**Re: Tract I-1 Mesa Del Sol, Innovation Park II
Grading and Drainage Plan
Engineer's Stamp dated 9-27-12 (R16/DA1003)**

Based upon the information provided in your submittal received 10-26-12, the above referenced report can not be approved for building permit based on the following comments:

SHEET TITLE
DRAINAGE MANAGEMENT PLAN
SHEET NUMBER
C001

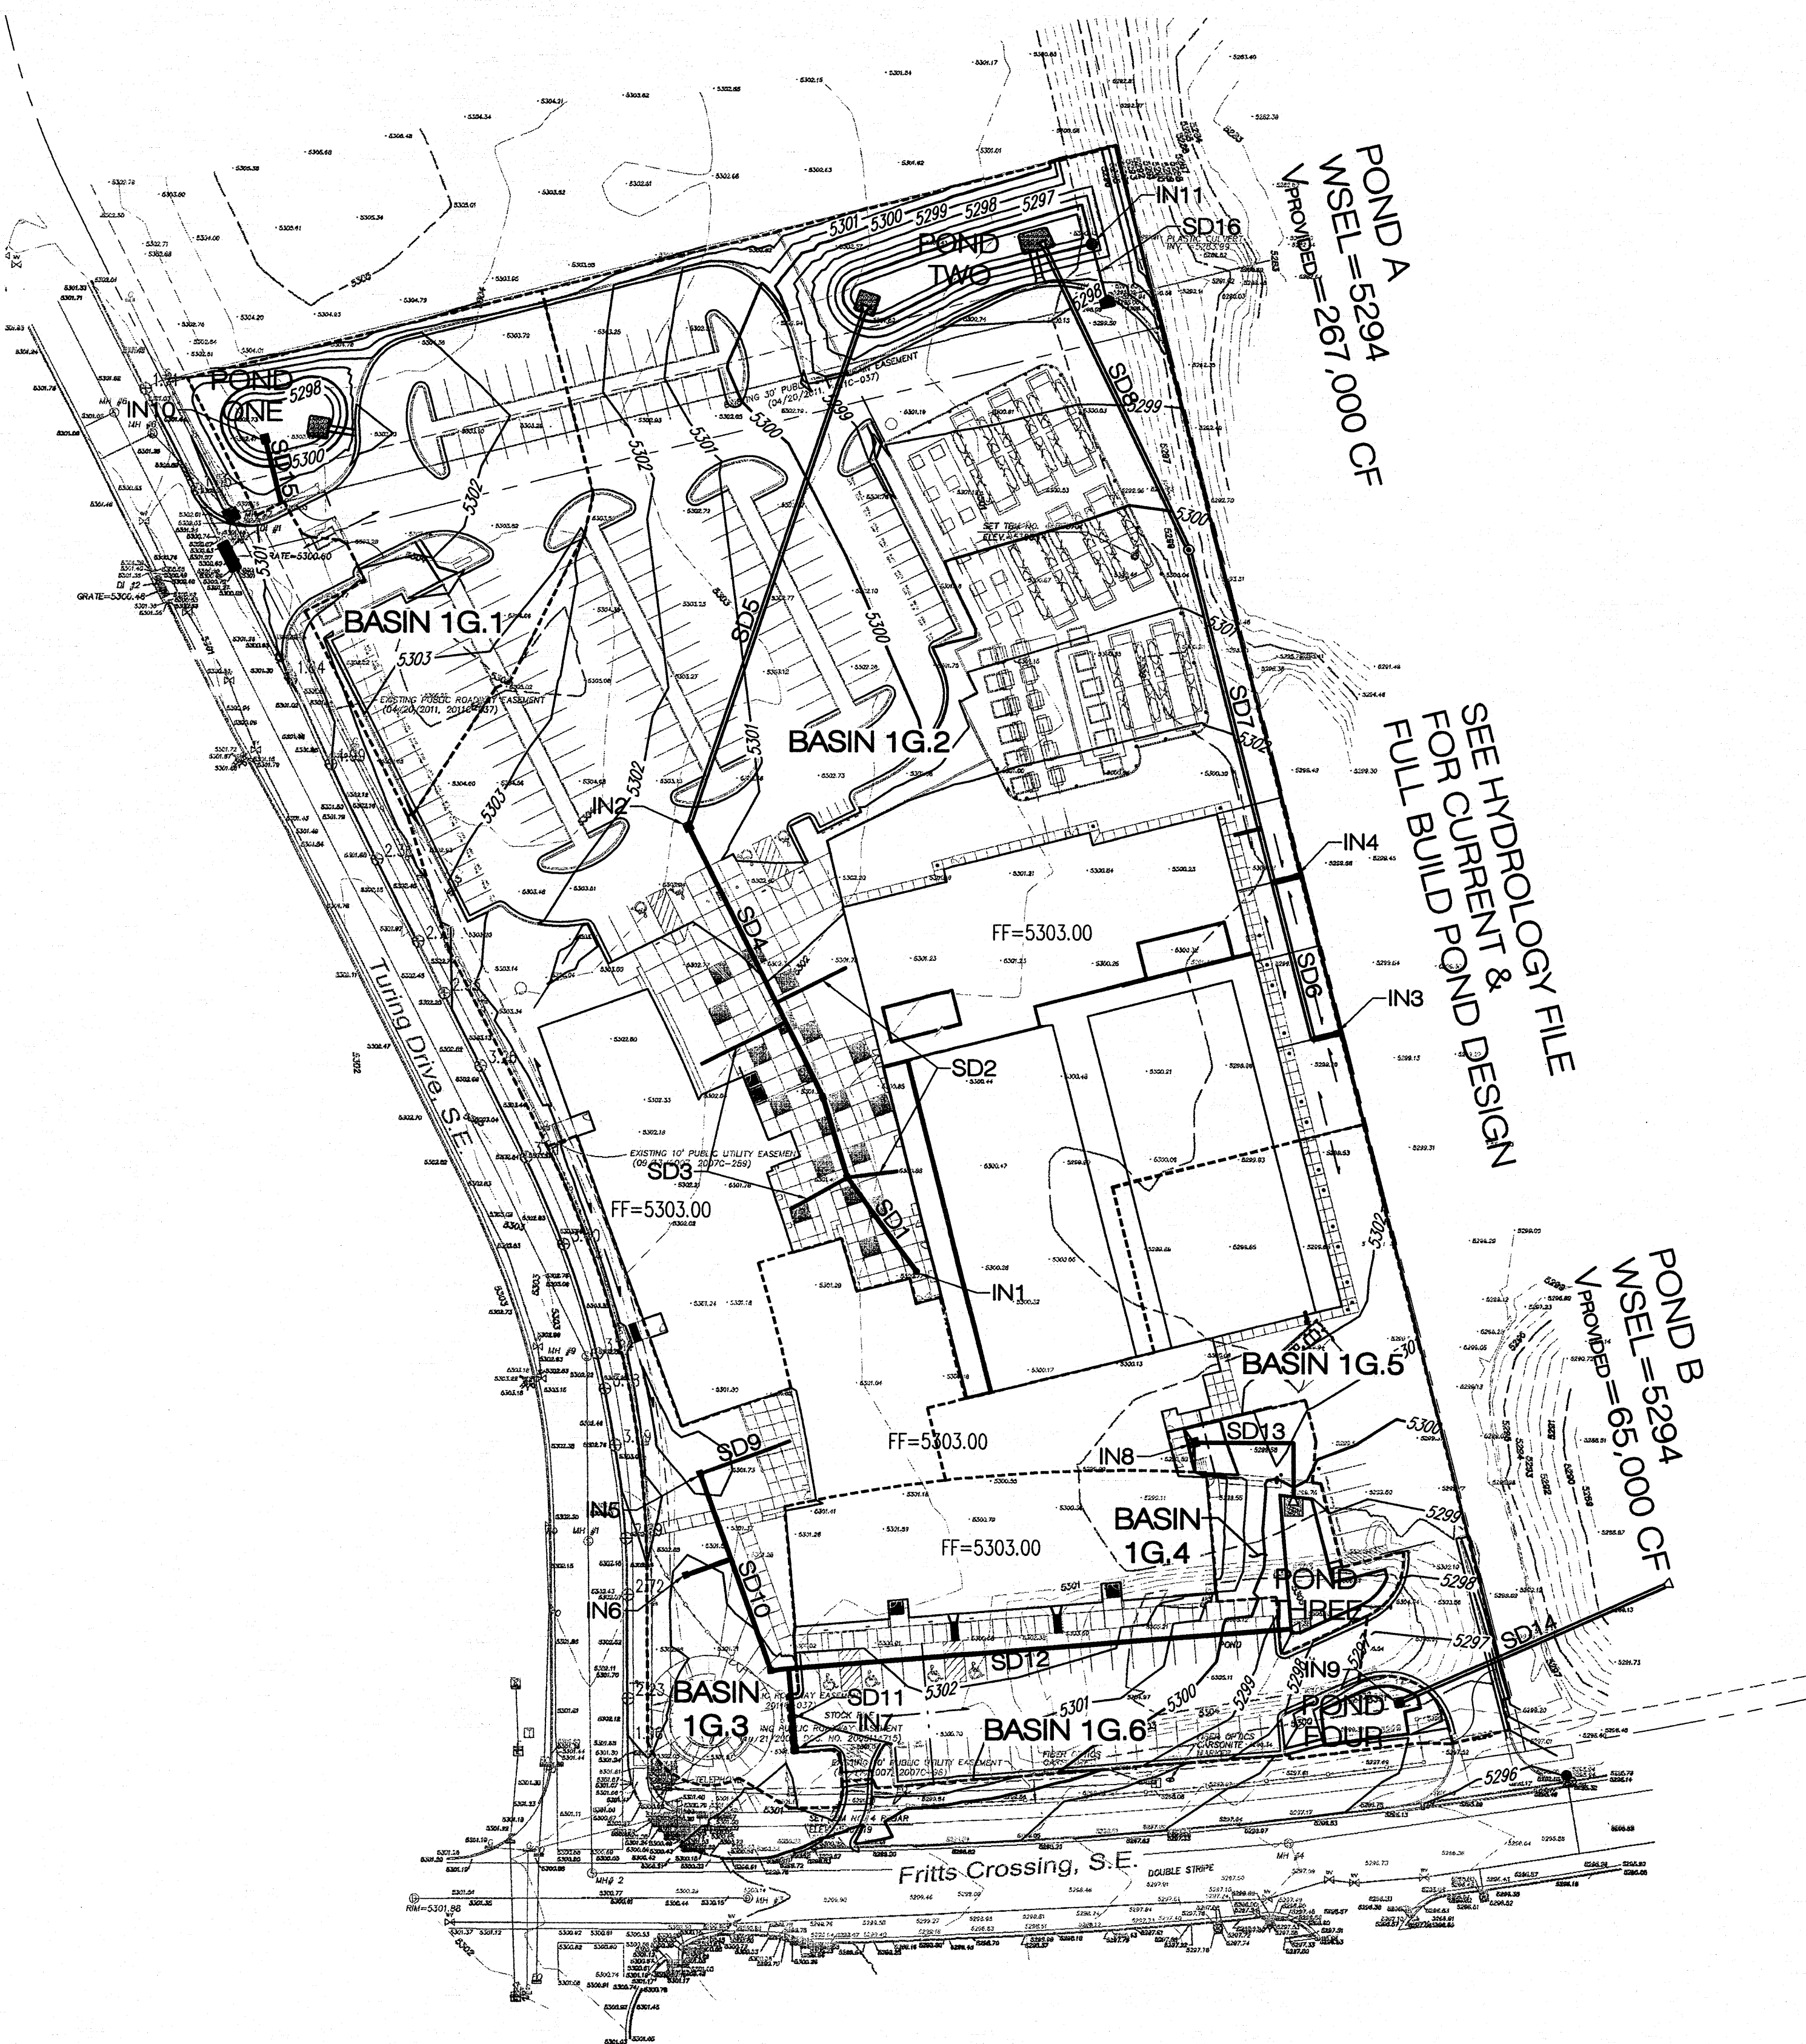
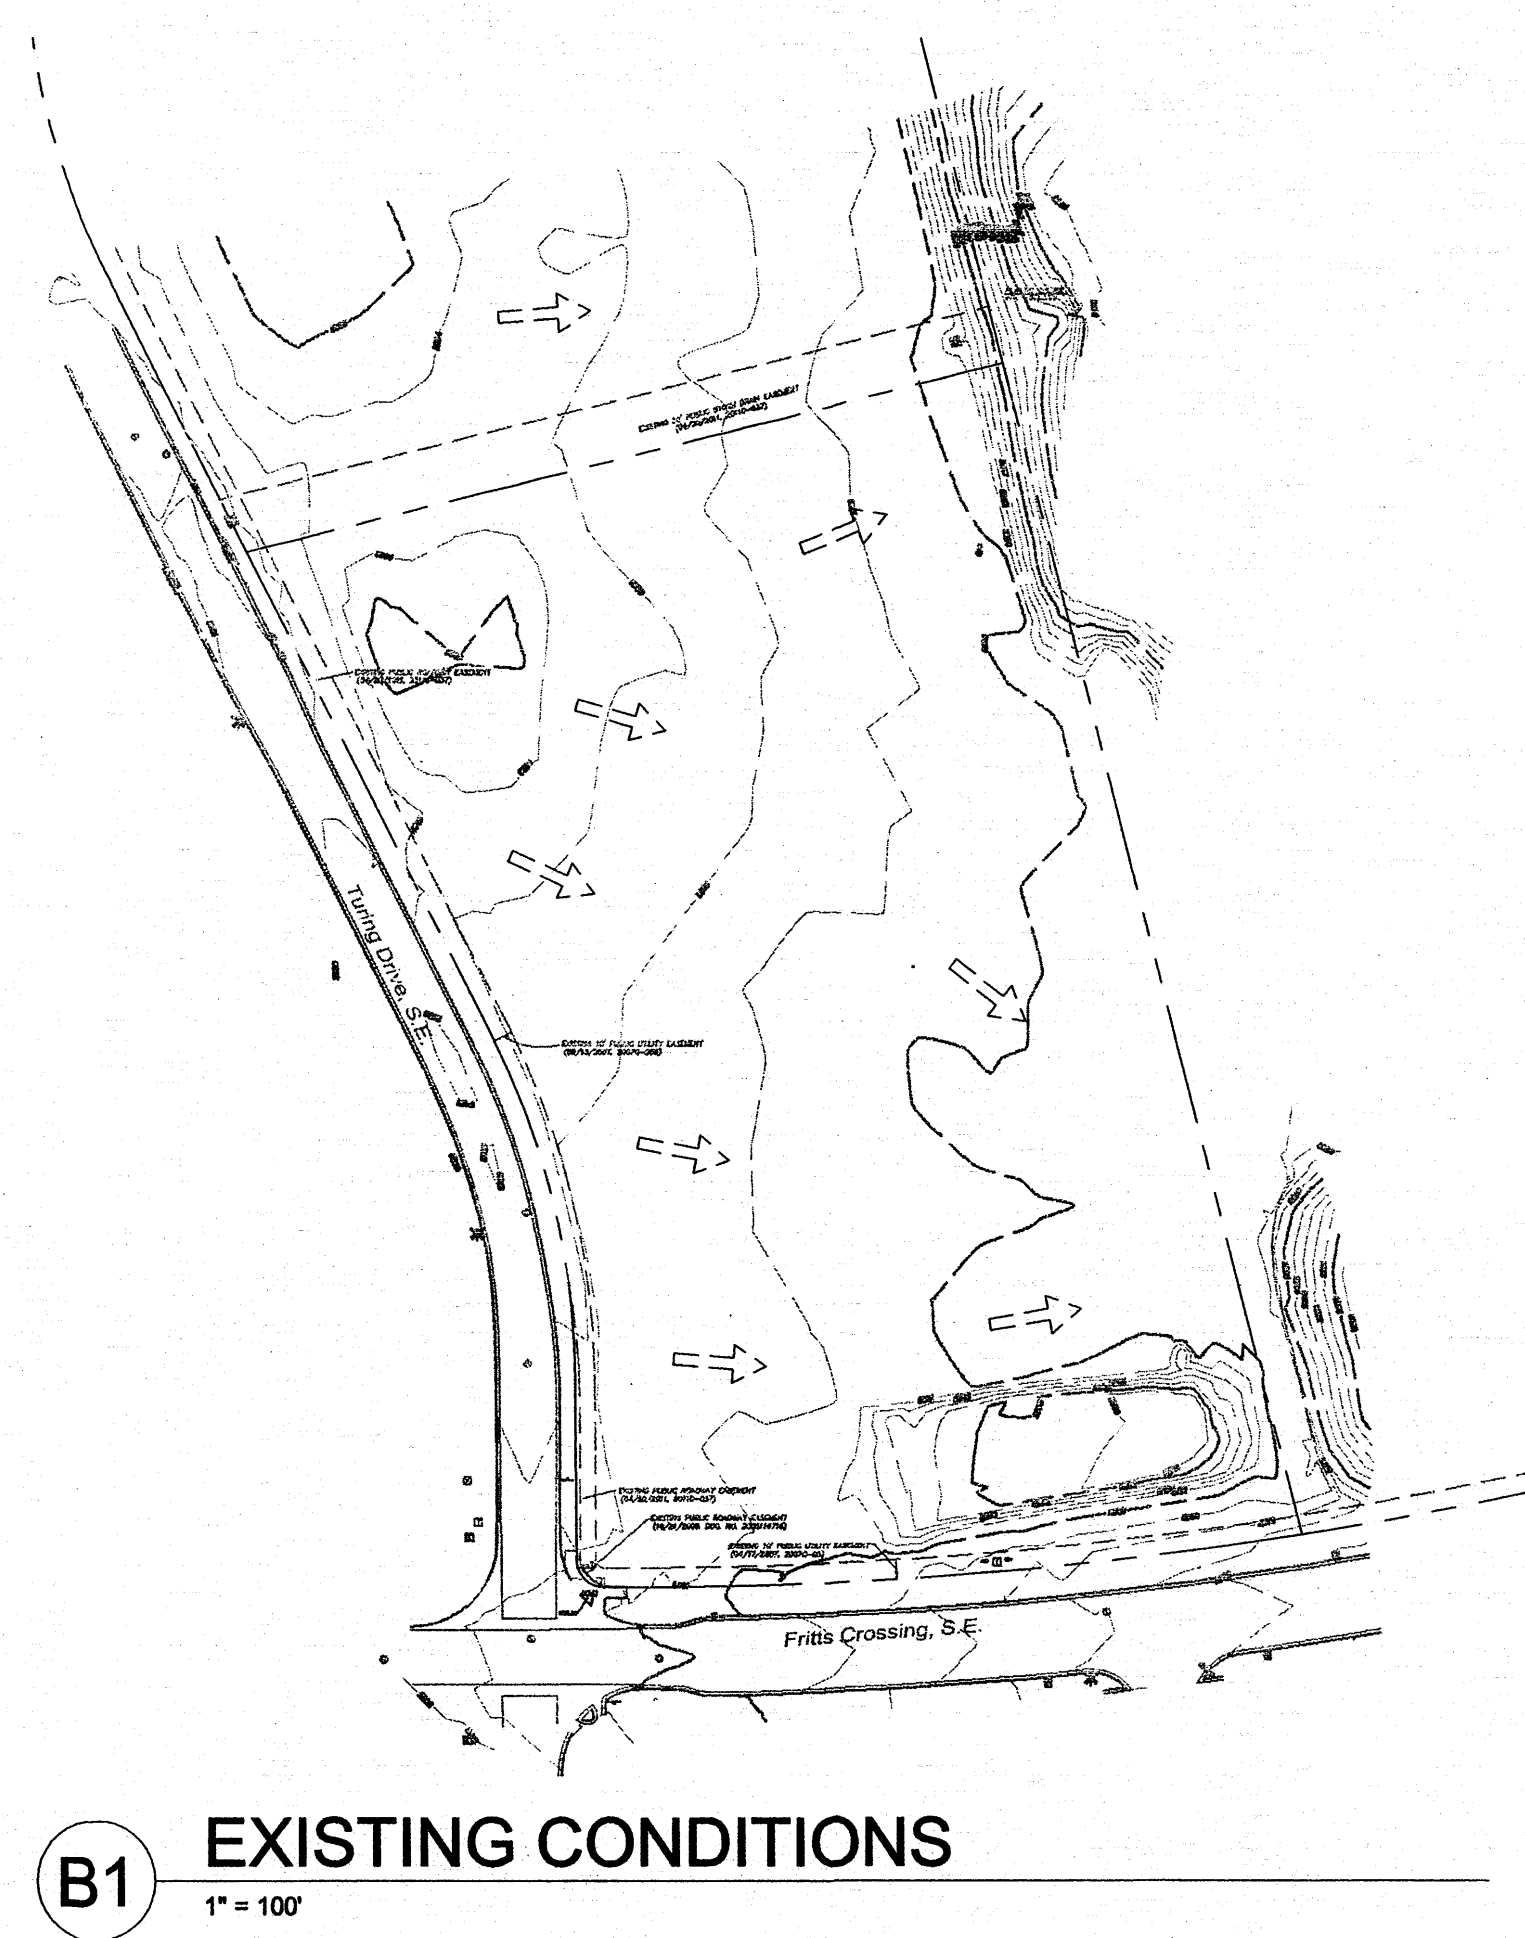
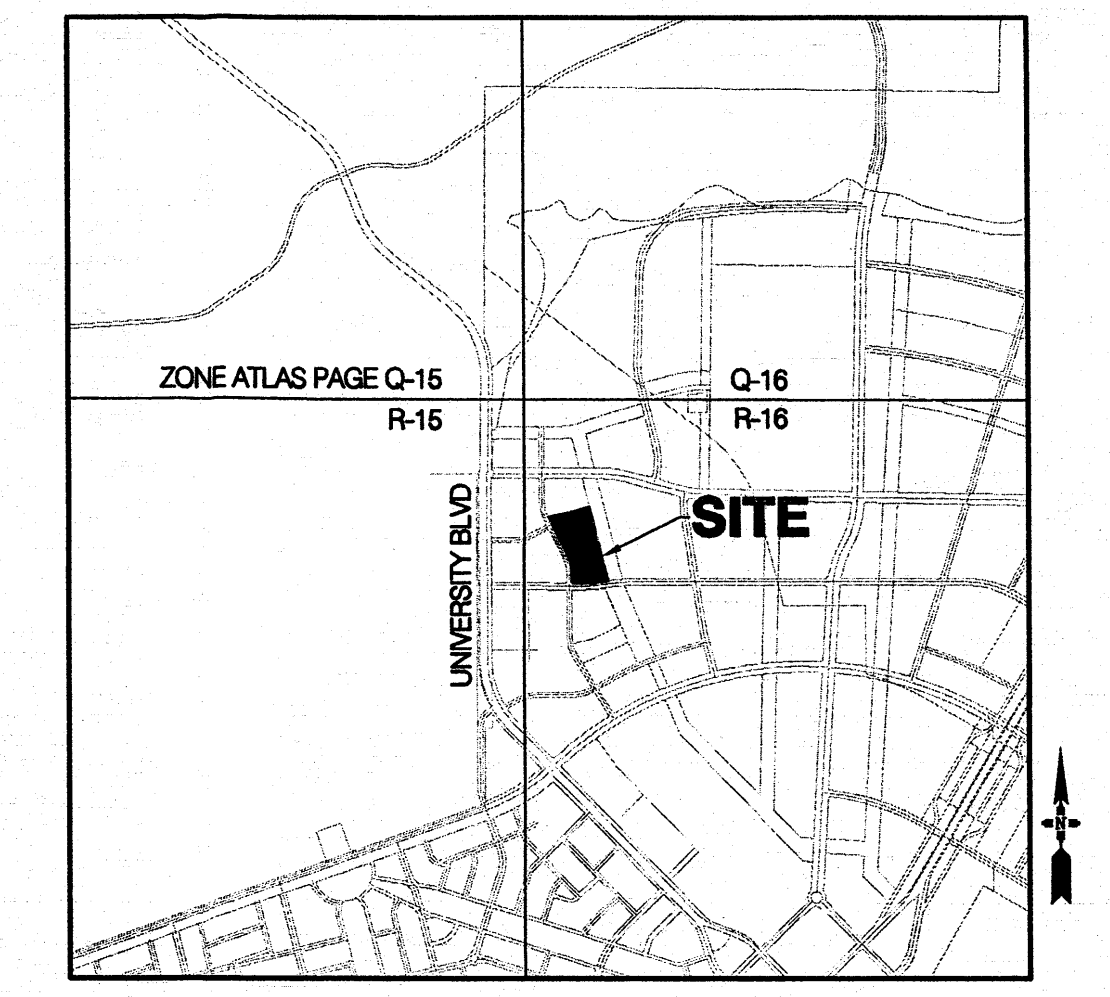
- The Volume and As-built grades for the existing ponds do not appear on the DRC plans (COA Project No. 775476). Please provide as-built grades and pond volume calculations for the existing ponds. Is the volume adequate for the existing runoff and the proposed runoff from this development?
- Provide Pond routing calculations. Call out the maximum water surface elevations.
- Are there any riprap being proposed at the discharge point of the pipes into Pond B.
